DRB Application No.: 05DRB-00712 (SBP)
Project Name: JOURNAL CENTER LOT 10A
Agent: John Klee

DRB Application No.: 05DRB-00711 (SBP)
Project Name: JOURNAL CENTER LOT 10B
Agent: John Kell

**CITY OF ALBUQUERQUE
PLANNING DEPARTMENT
May 11, 2005
DRB Comments**

RE: Lots 10A & 10B, Journal Center/SPBPs

SITE PLAN
SCALE: 1"=10'-0"

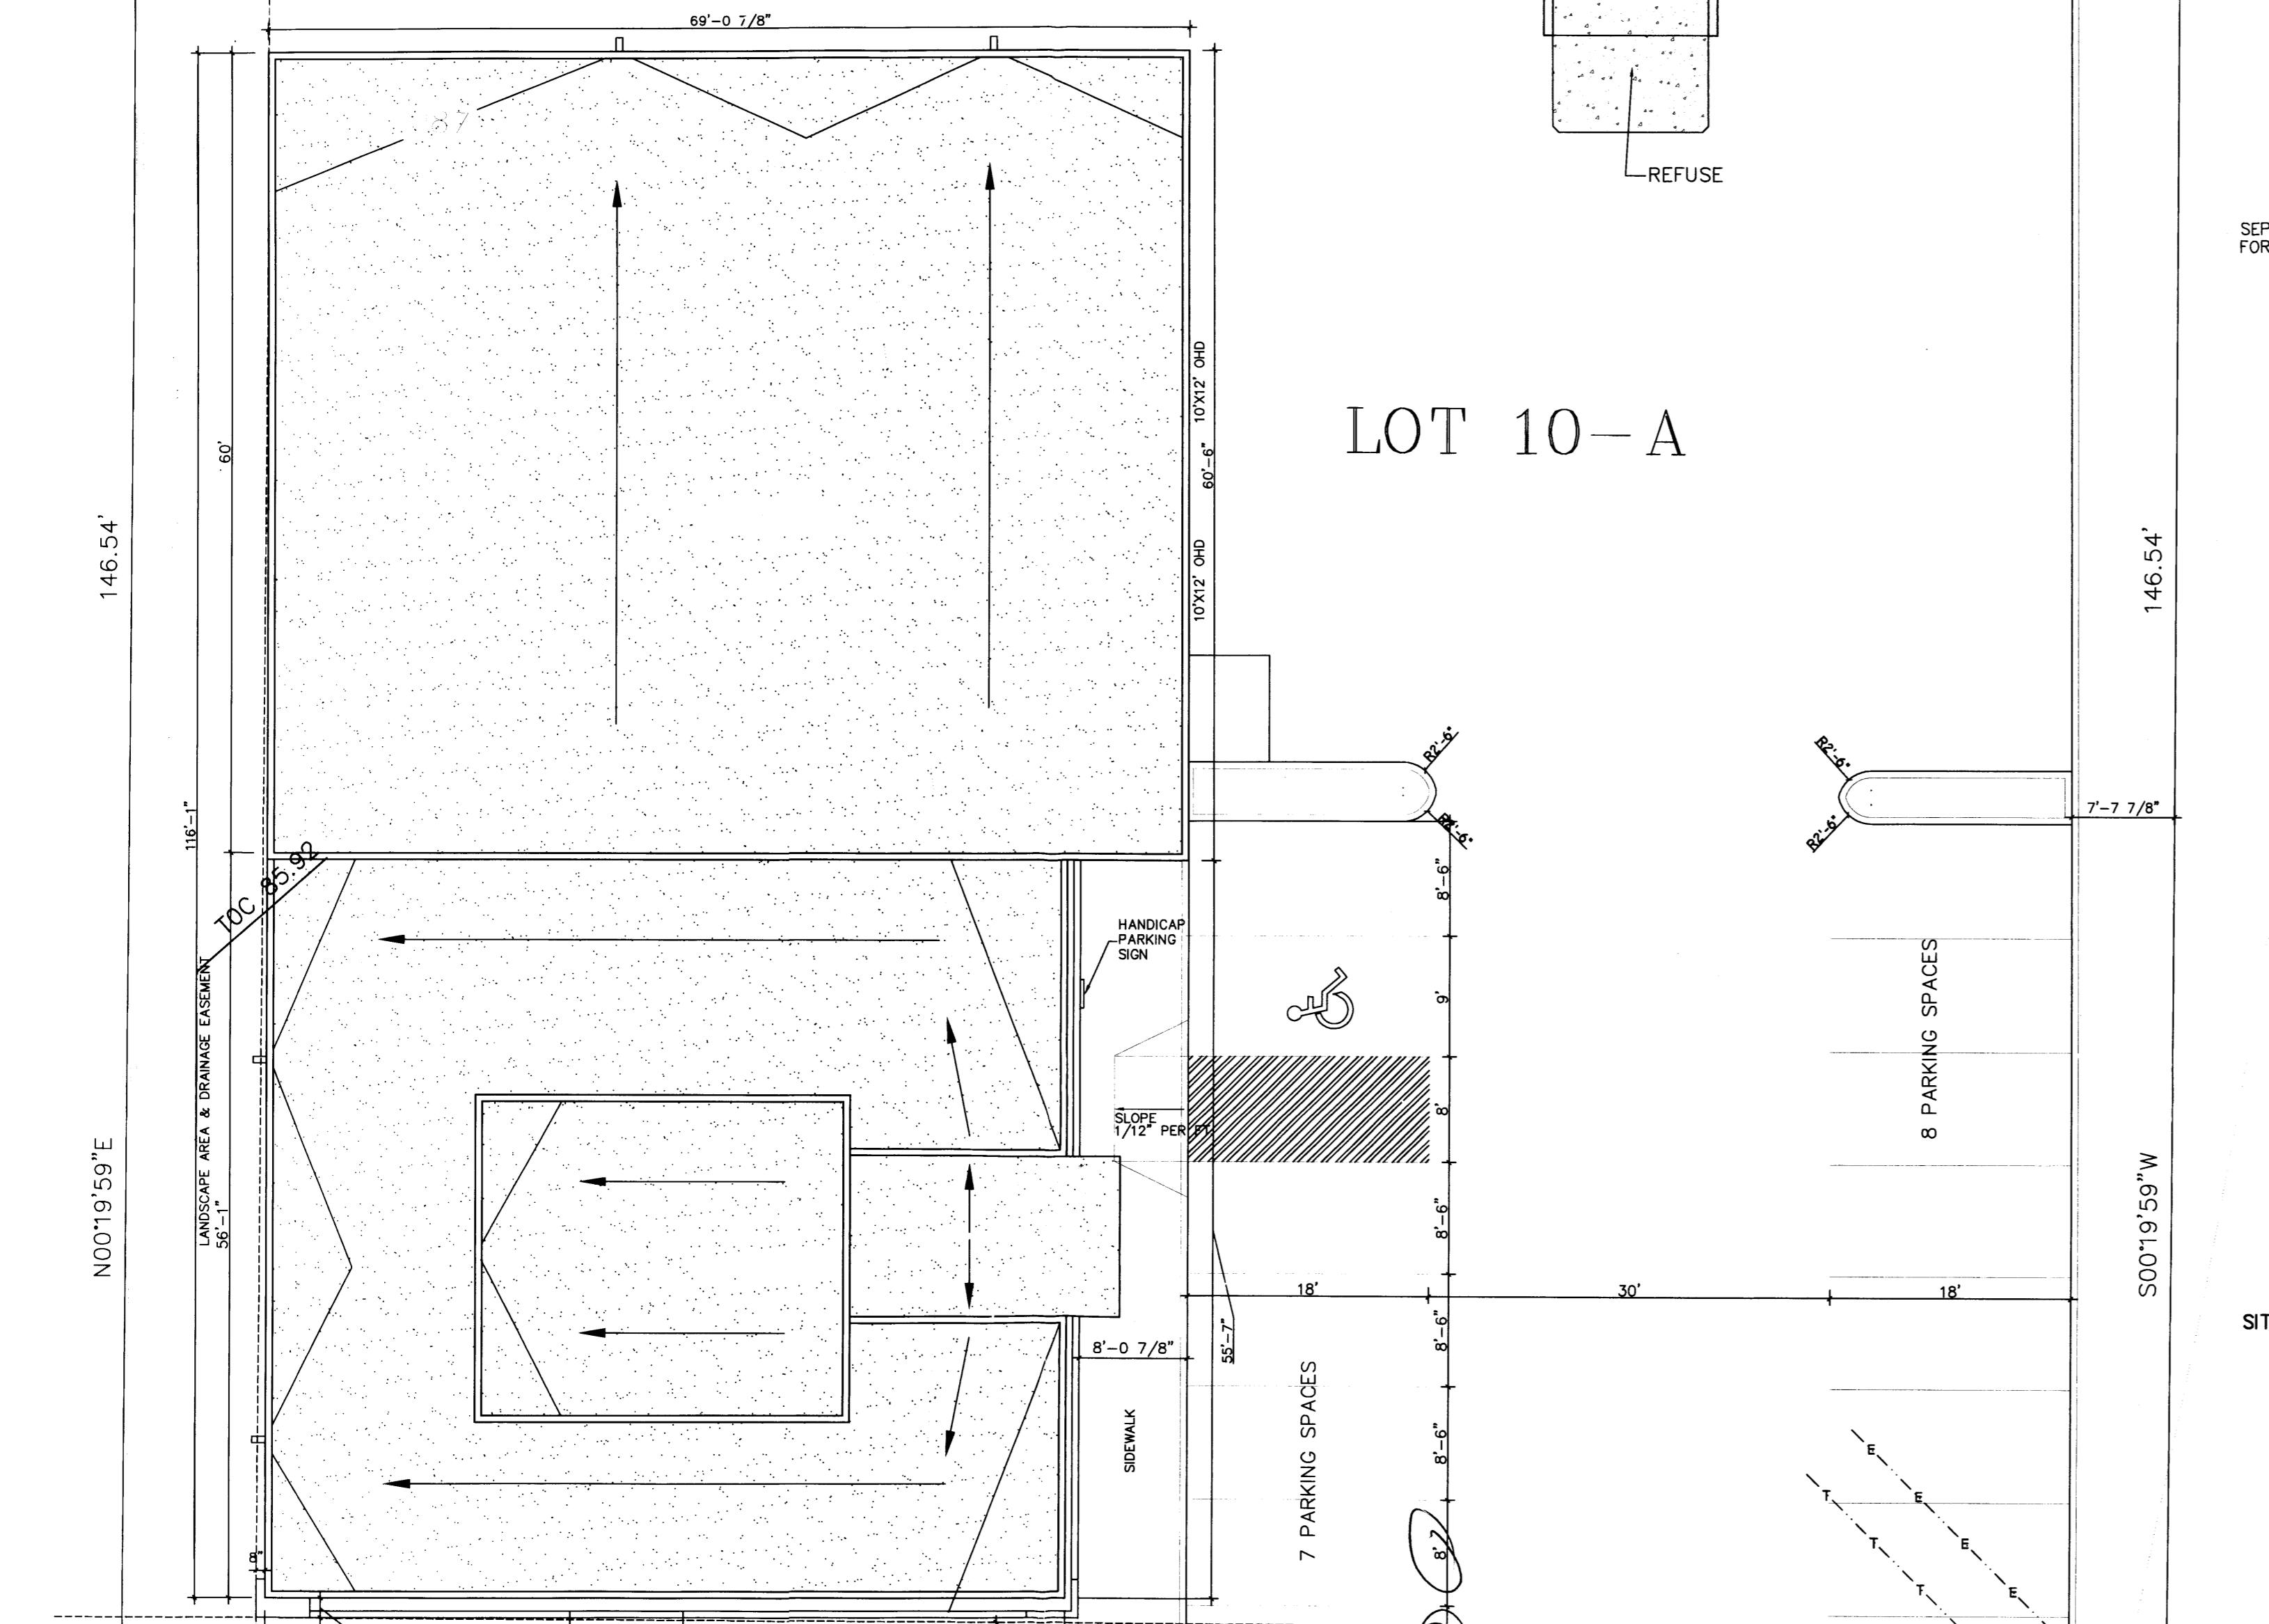
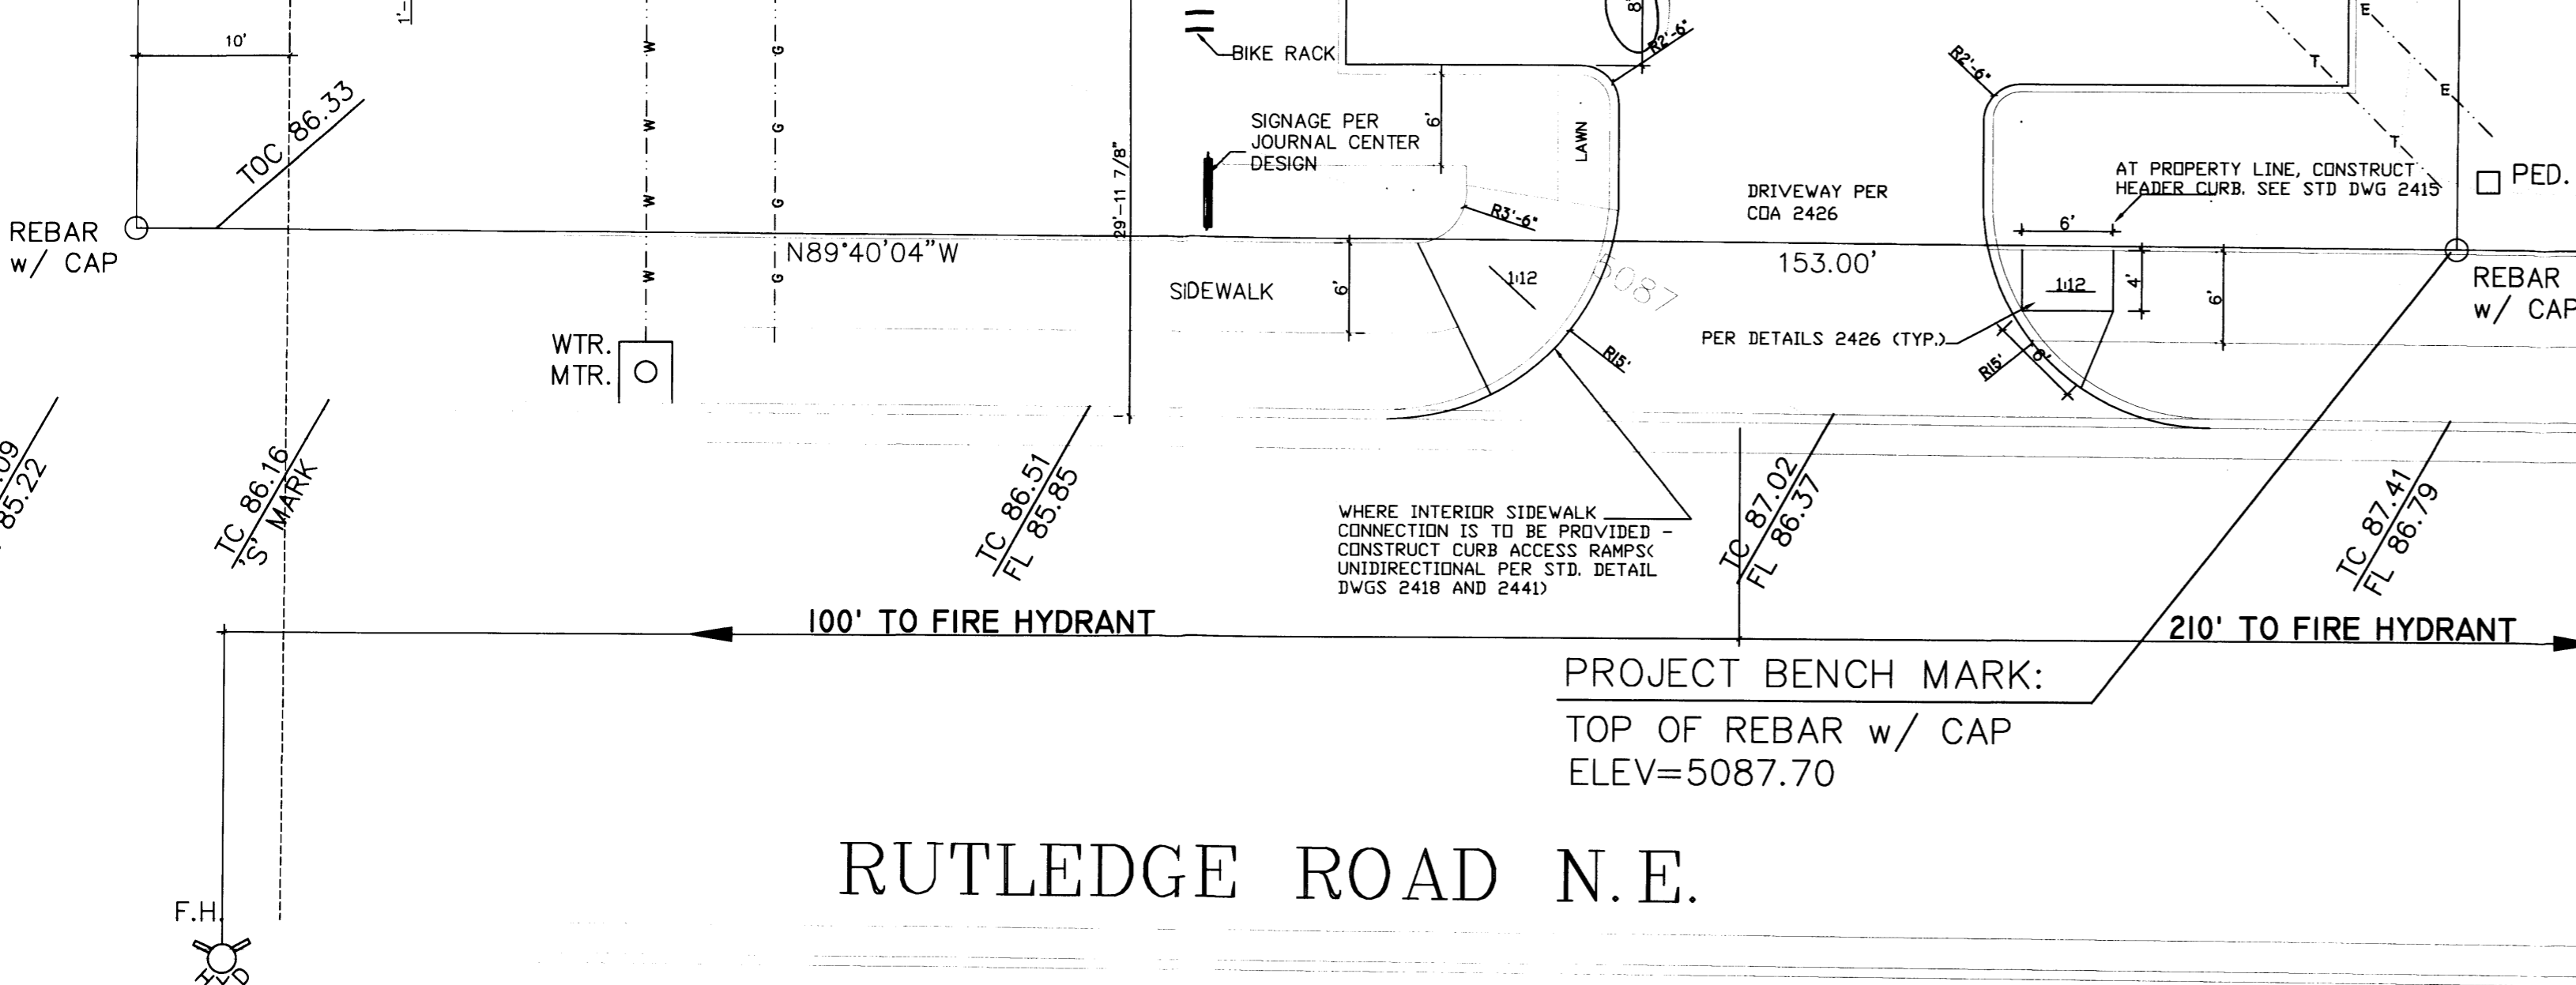
TRANSPORTATION: Stall dimensions
sidewalk reflagation *AK*

TRANSPORTATION: *Stall dimensions*
sewer relocation

JOB TITLE: JOURNAL CENTER LOT 10A			
REVISION:	FILE NAME	JOB NO.	DATE
05-05-05			03-11-05
SHEET TITLE: ELEVATIONS			DRAWN BY: RI KB

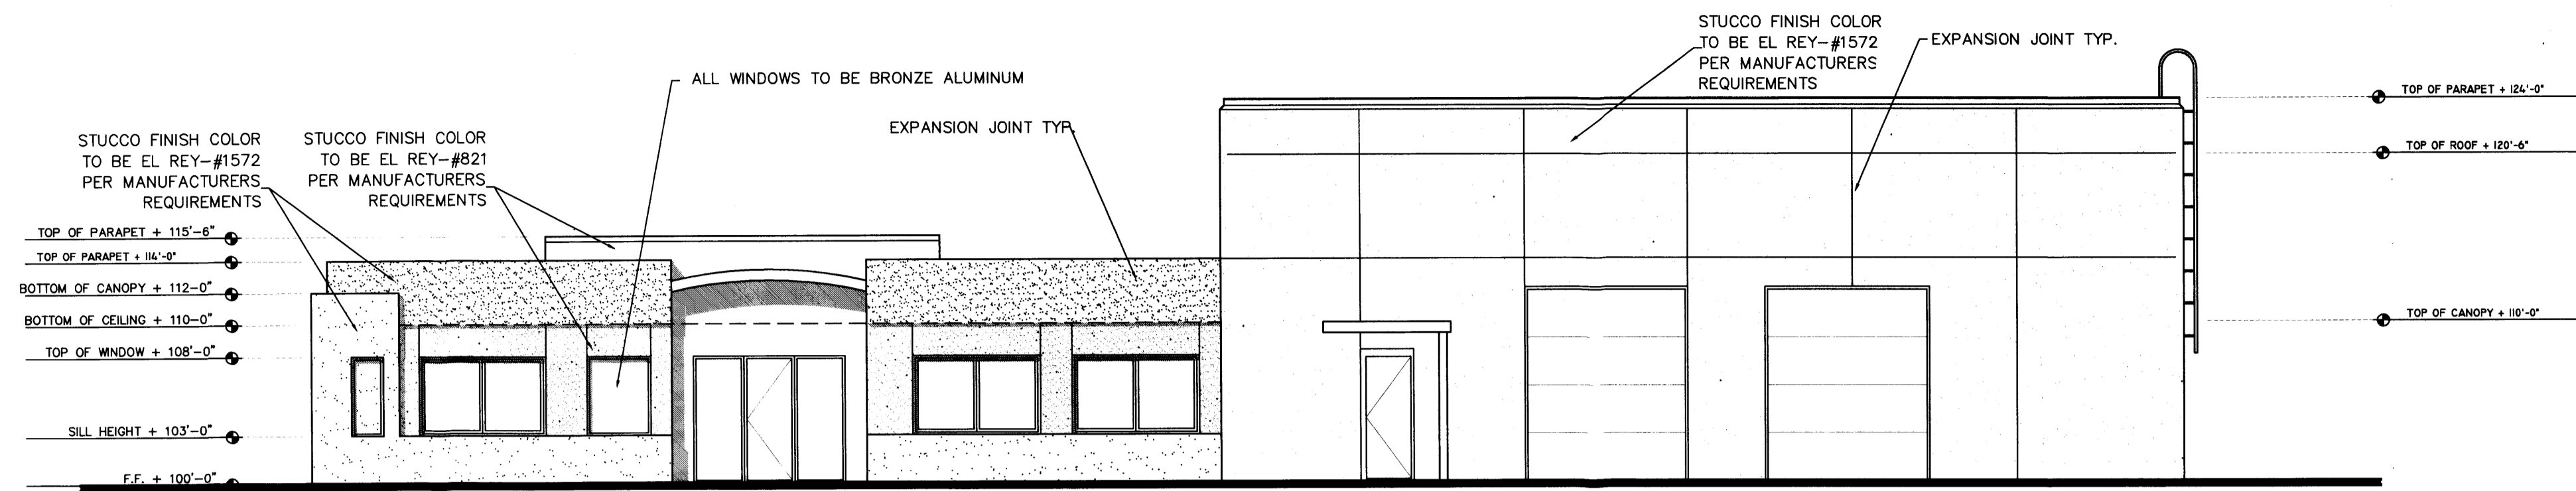
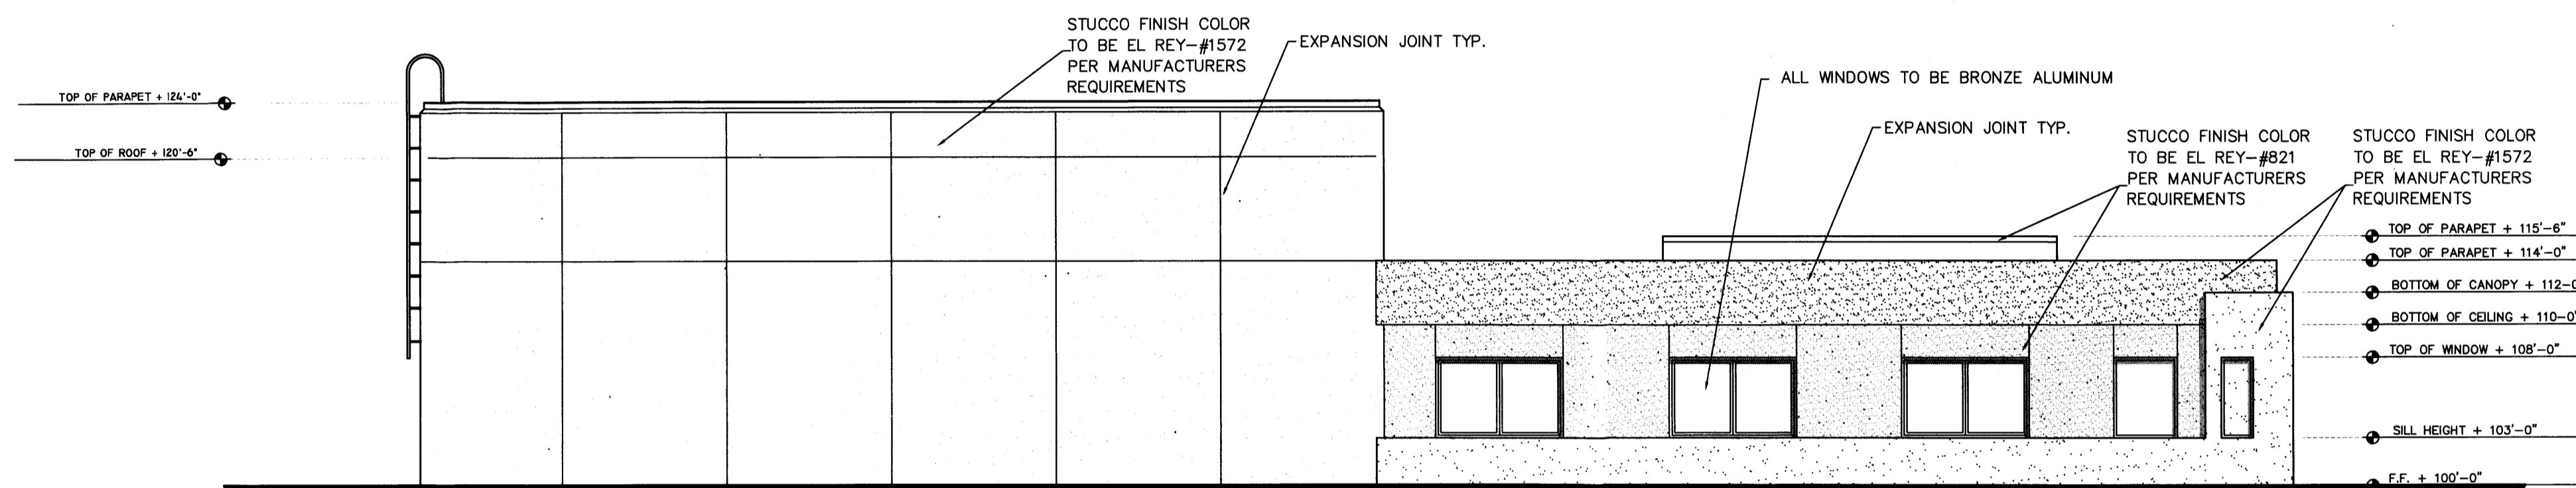
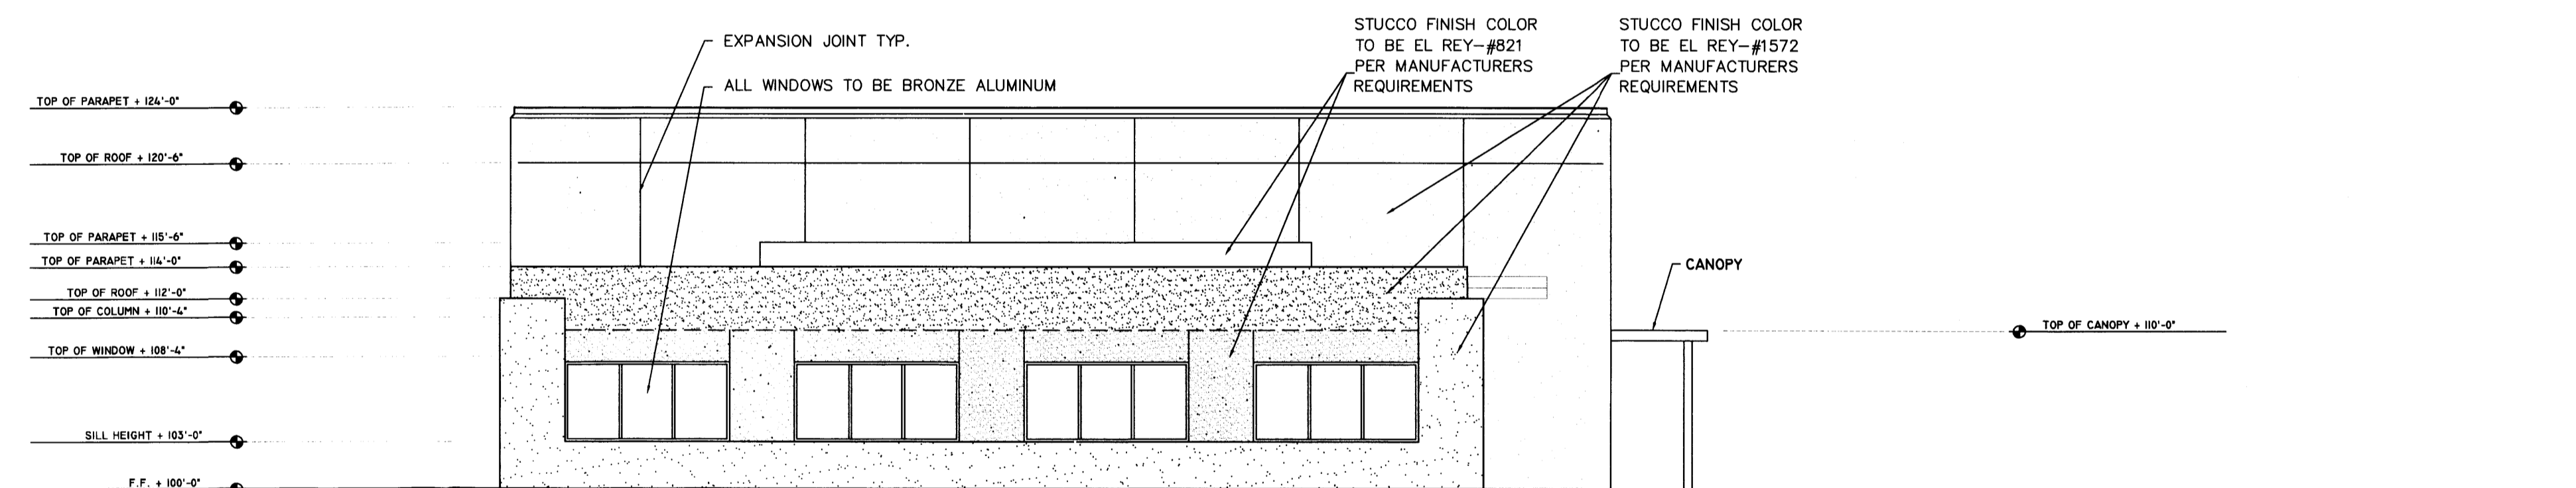
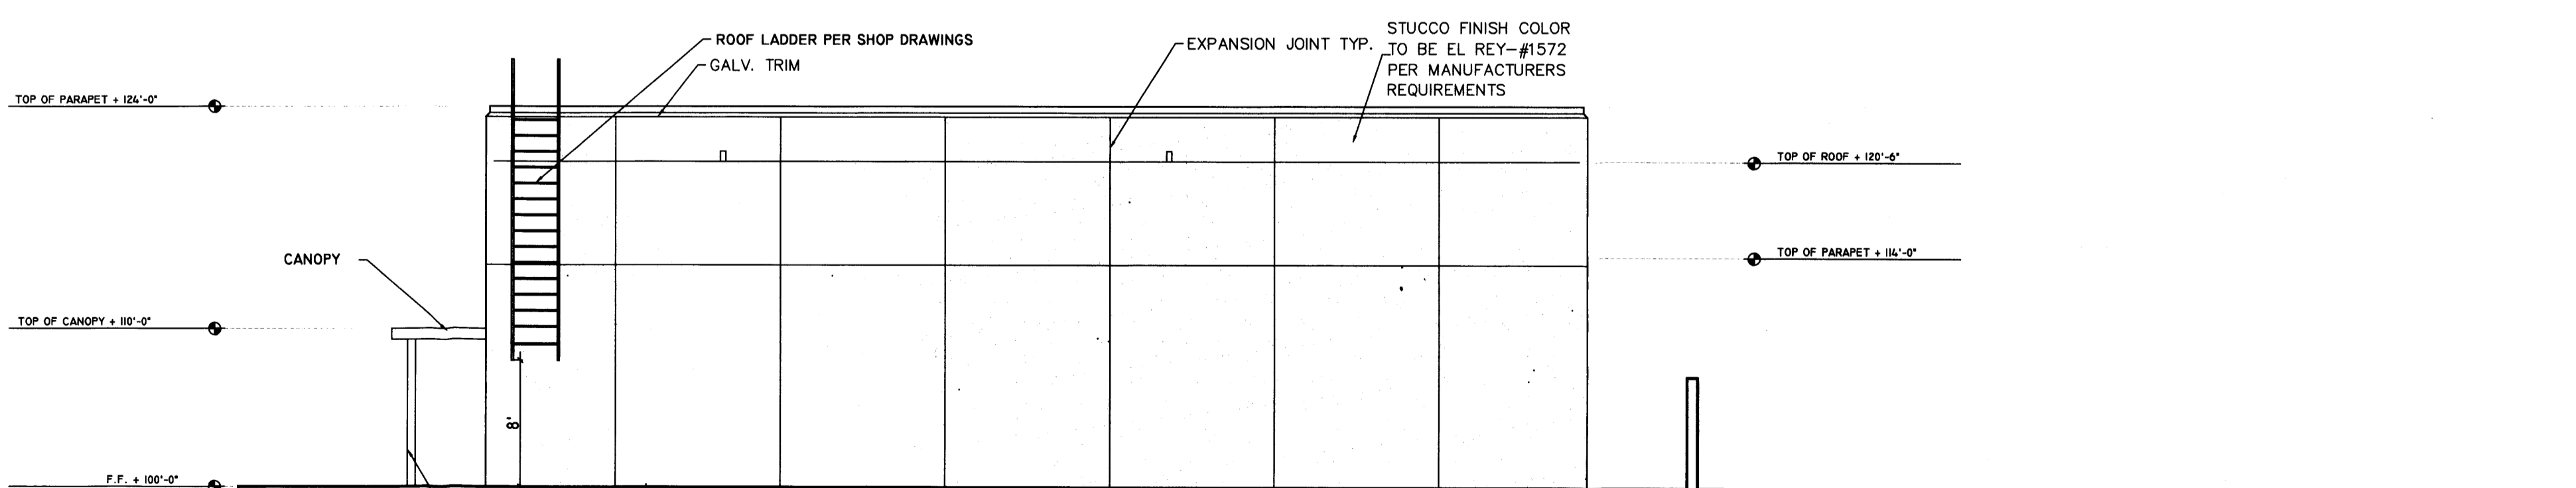
1. The Journal Center ARC approval letters are needed for Planning approval.
2. The property lines are not clearly indicated on the Landscape Plans as required.
3. All of the existing easements are not show on the site plans. For example, the 10' PUE on the plat is missing from both site plans.
- ✓4. Several items on the checklist are neither checked nor marked with an "n/a" and explanation as to why they are "n/a".
5. Easements are missing on the Landscape Plans as well.
6. Location arrows indicating which landscaped area the square footage is for are needed.
7. Overall building width dimensions are missing on the Elevations sheets.
